**Consultation Response from KC,
 Trees**
2021/91638 Land at Hart Street, Newsome, Huddersfield, HD4 6LS
Reserved matters application pursuant to outline application no.2016/91479 (appeal no. APP/Z4718/W/17/3173711) for erection of 22 dwellings
Date Responded: 11/06/21
**Responding Officer: Nick
 Goddard**
Responding Ref: TPO 18/95

PLANNING
DRAWING

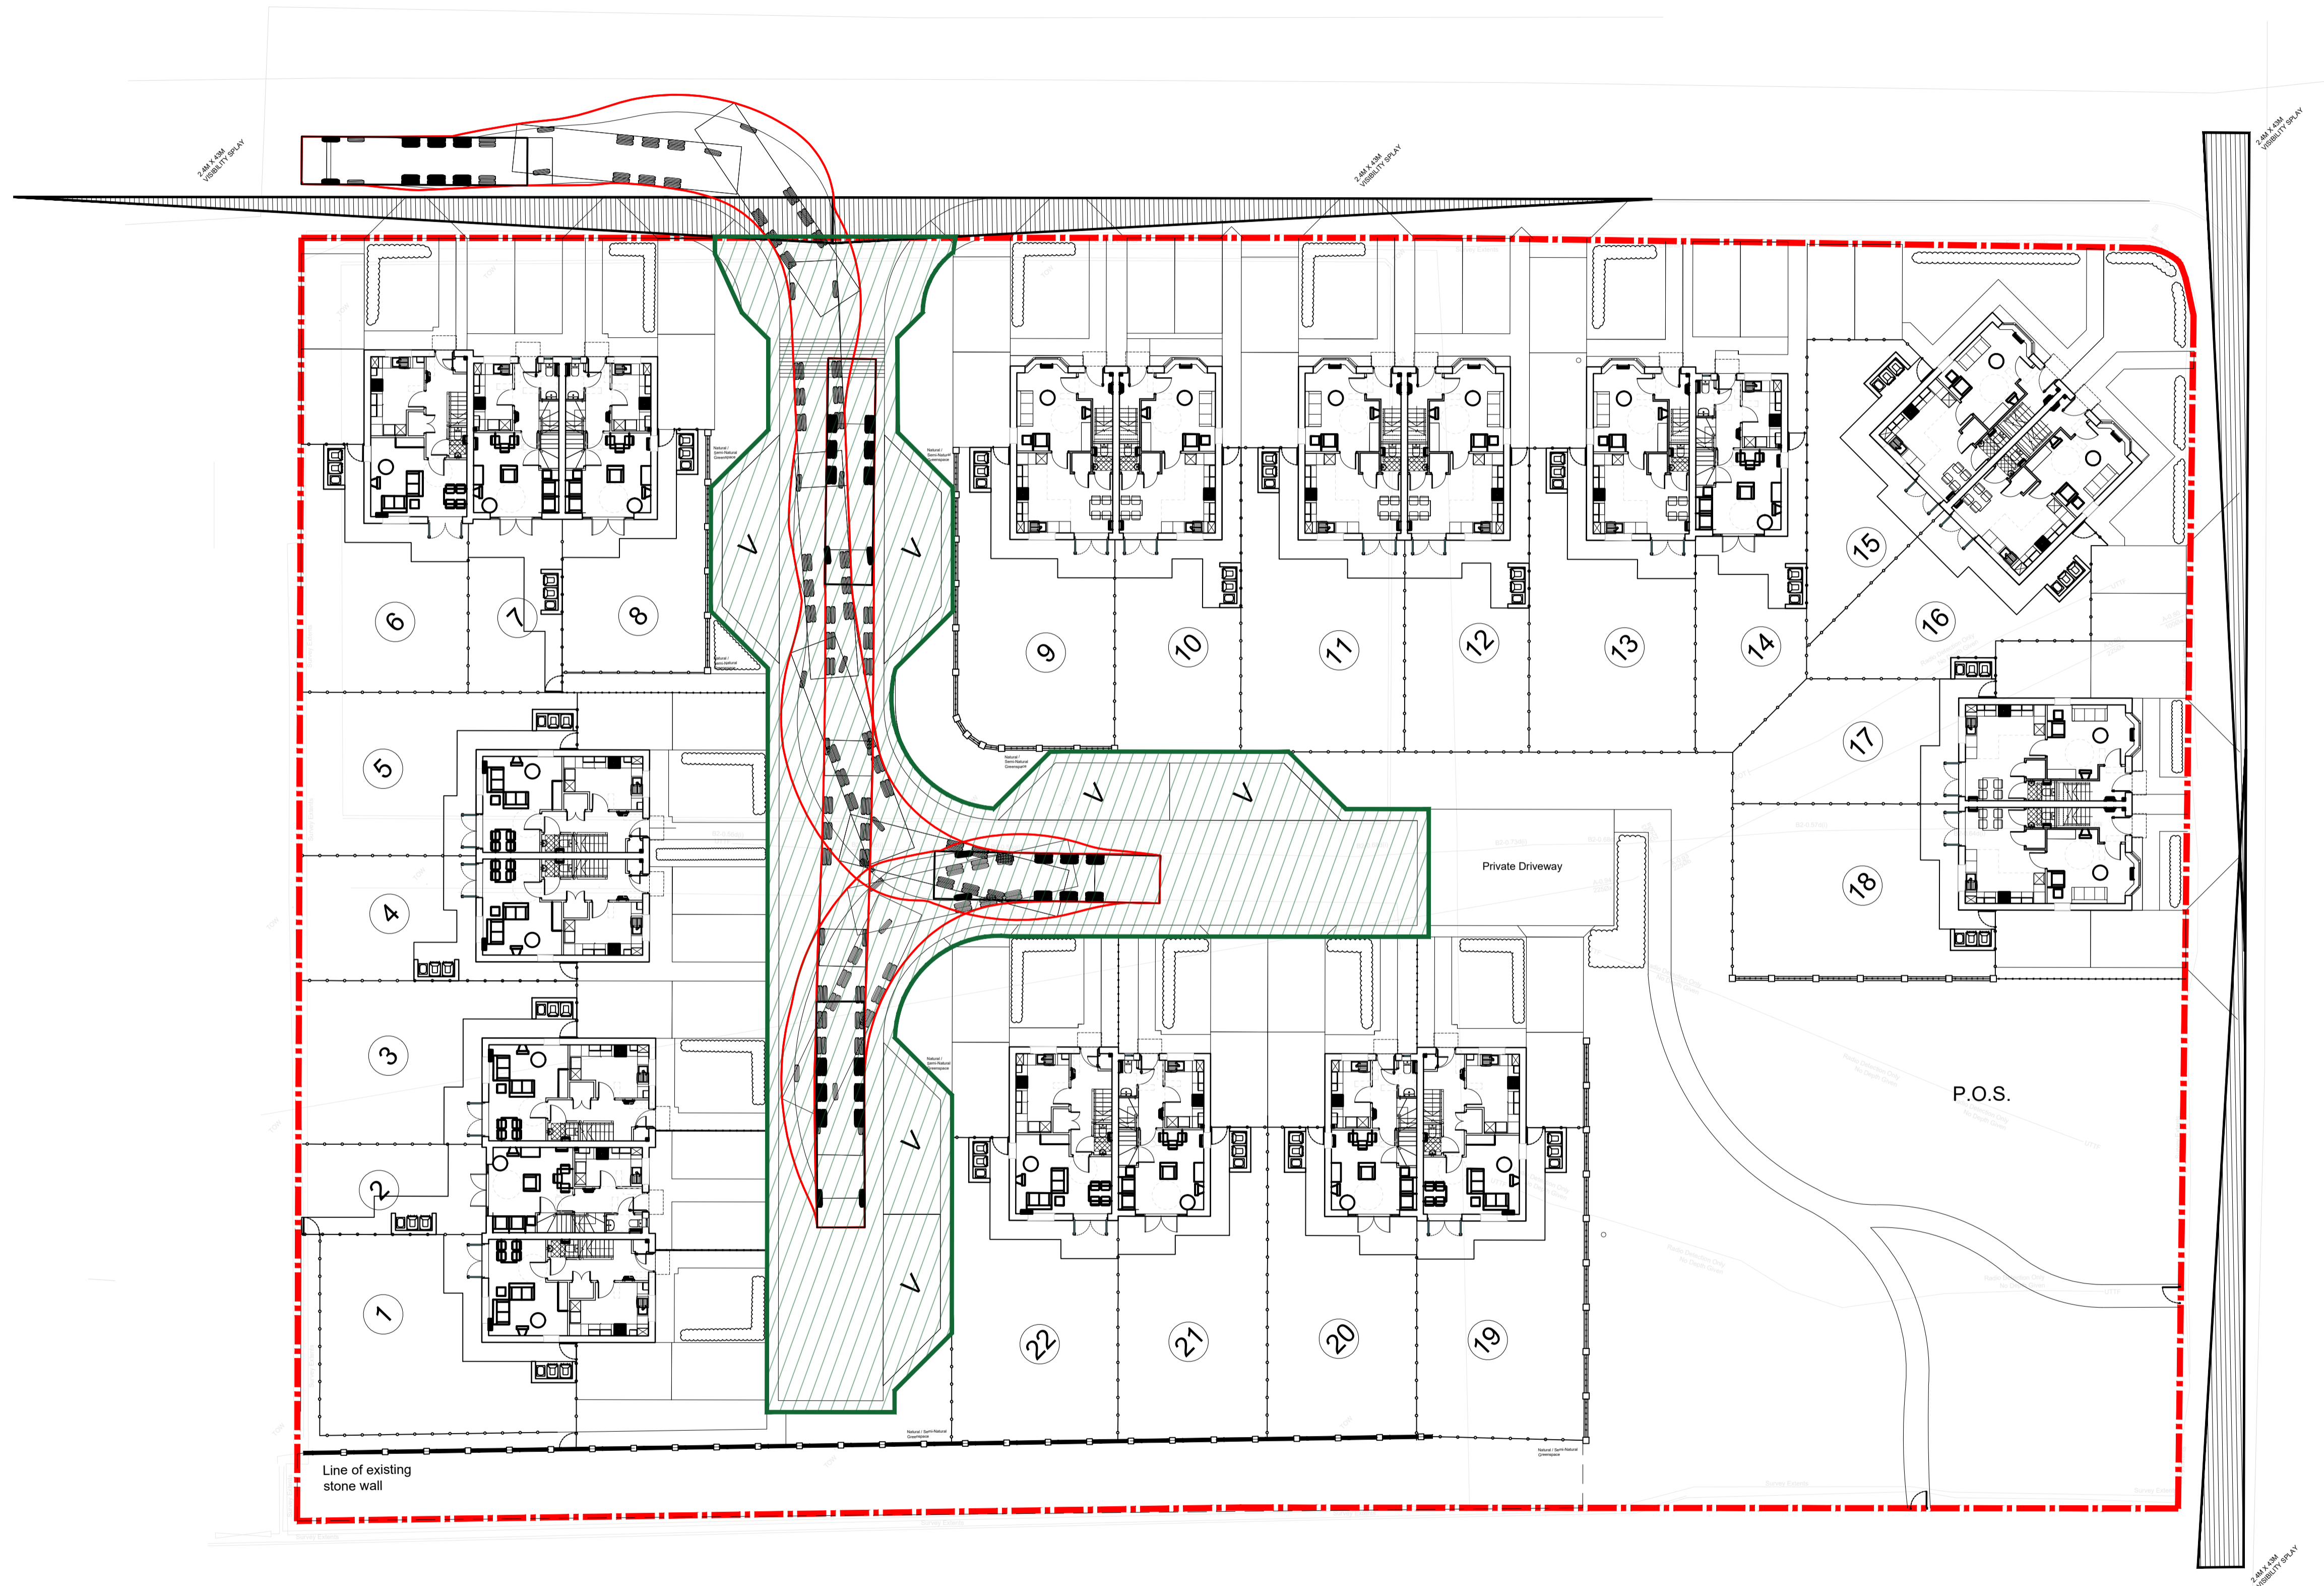
The plans submitted do not appear to plot the tree canopies' true extents and show the tree centres to be within the road at the mill end of Naomi Rd. I do not think there is enough information at present to be confident the tree constraints have been taken into account or that the trees will be successfully retained.
